DEVELOPMENT REVIEW COORDINATOR  
POST APPROVAL PROJECT CHECKLIST

Project Name: Liberty Bay Recovery Center

Site Plan ID Number: #2017-086

Project Name:	Liberty Bay Recovery Center	Project ID:	2017-086
Address:	343 Forest Avenue	CBL:	112-D004
Applicant:	Nathan Cermelj		
Planner:	Matthew Grooms

C2.1

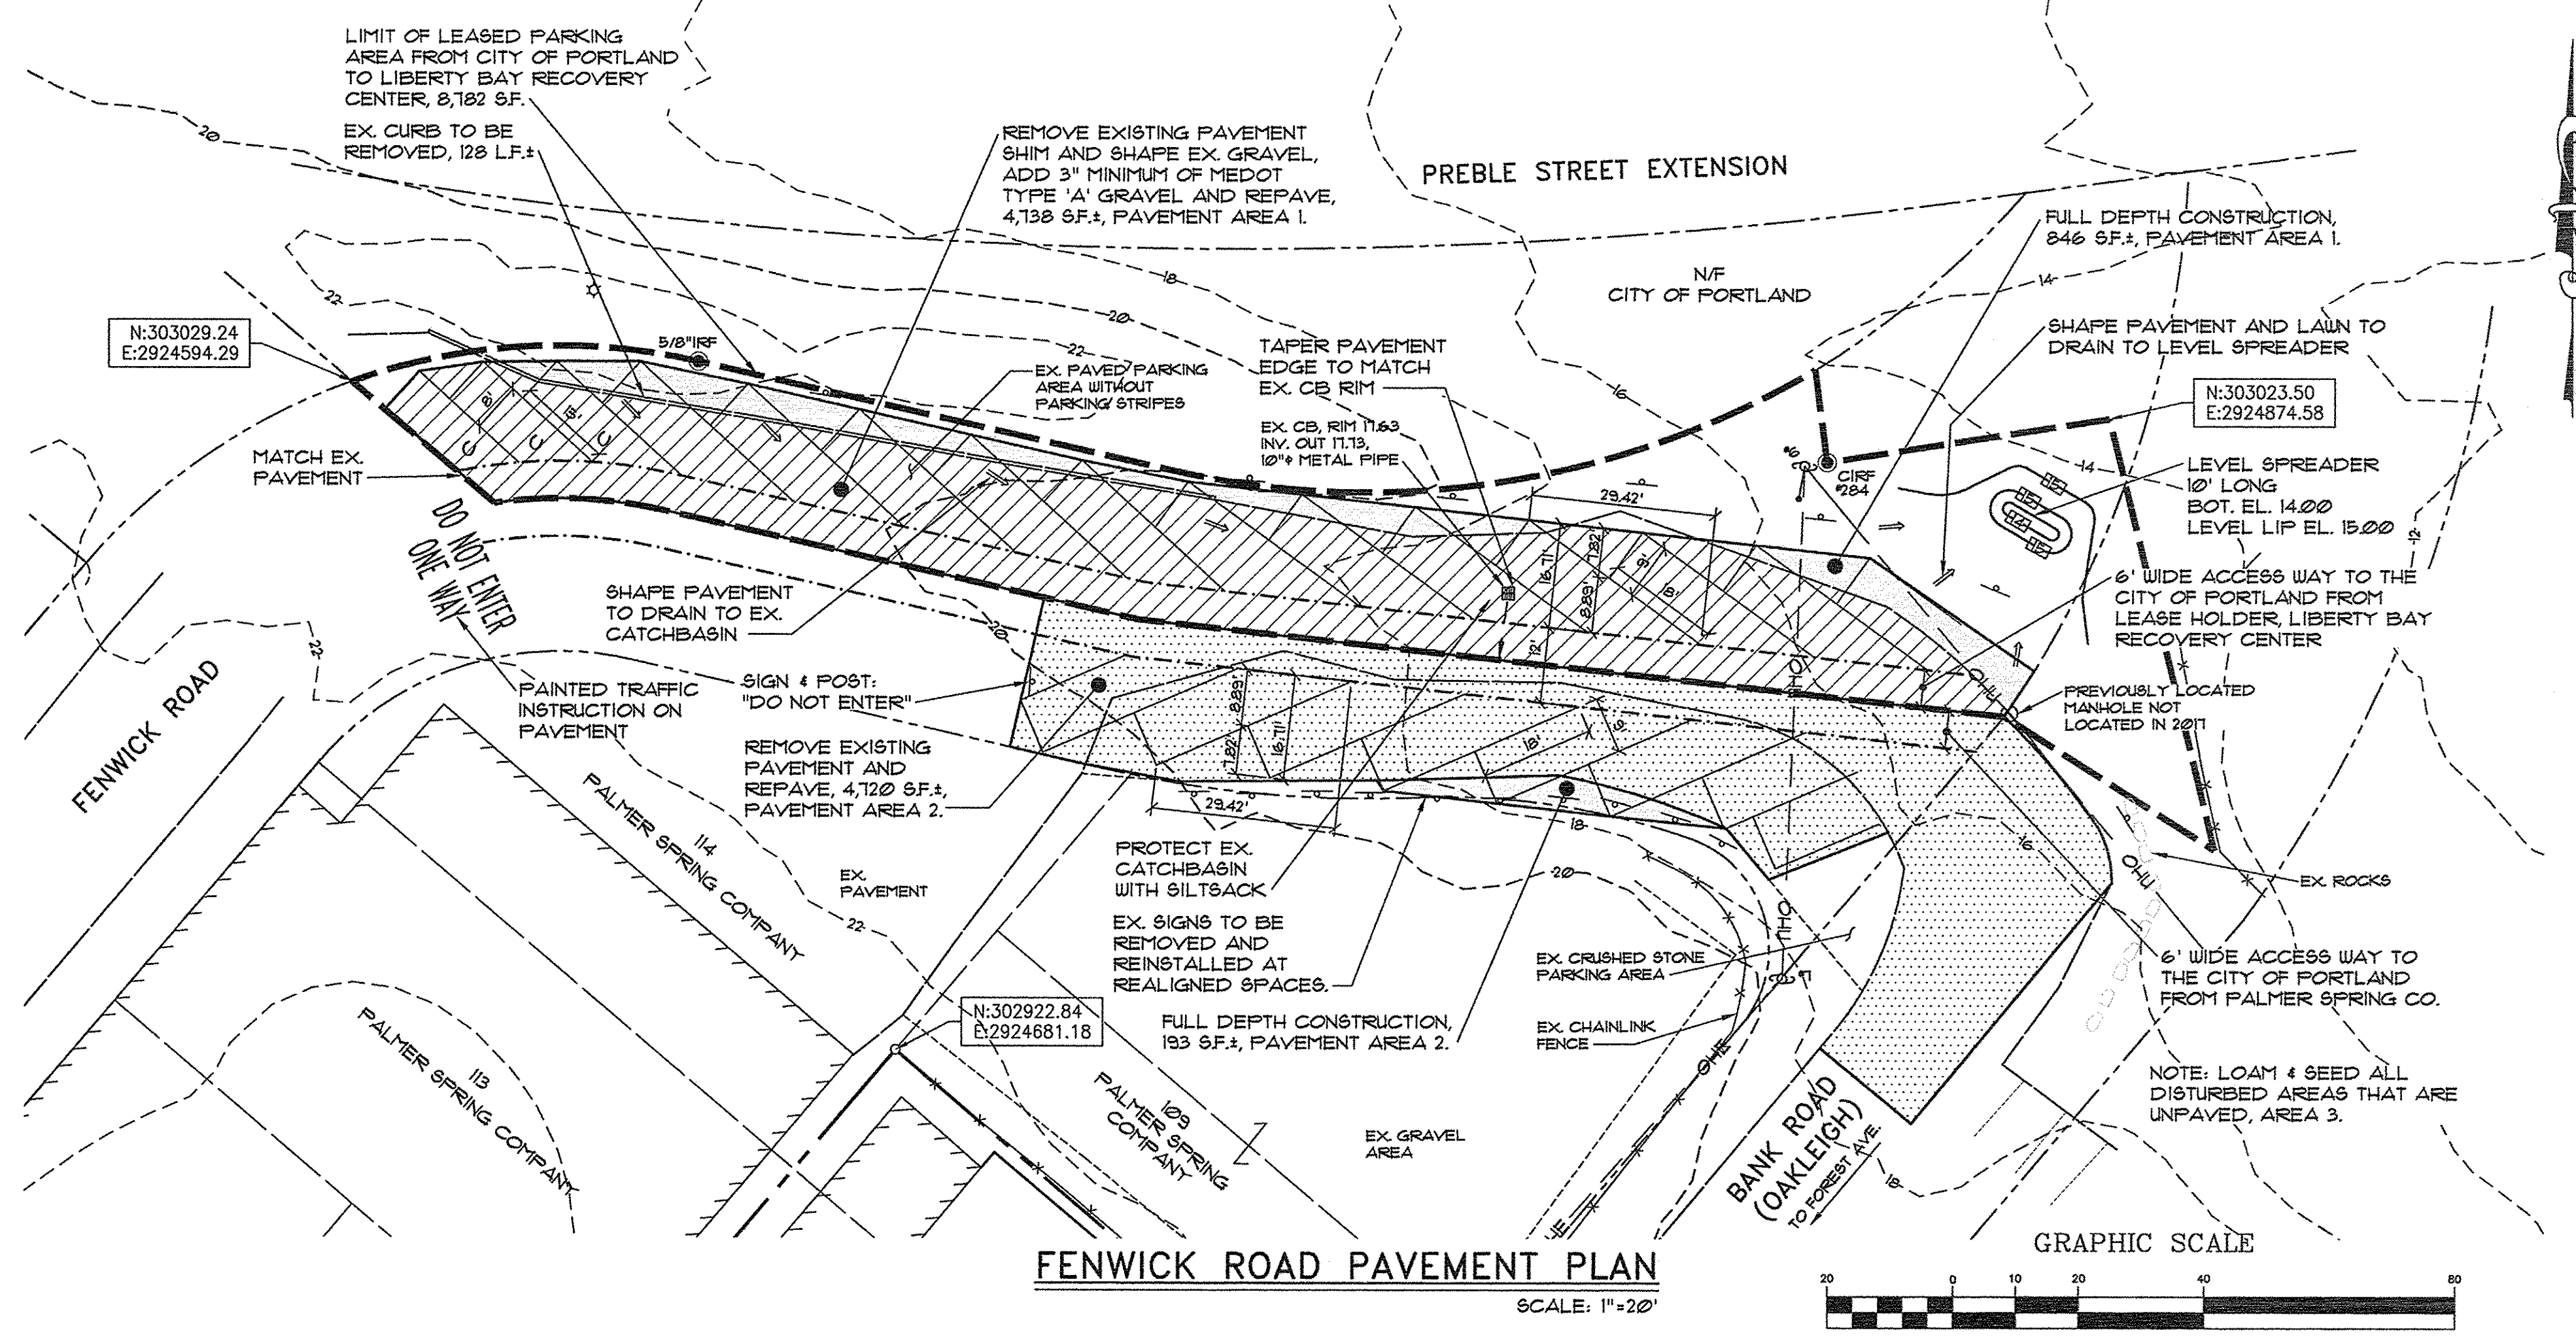
3. The two access way notes found on Sheet C2.1 reading "6' wide access way to the City of Portland from..." shall be consolidated into one note reading "Maintain a 12-foot wide vehicles and pedestrian public access centered on the lease limit line"; and
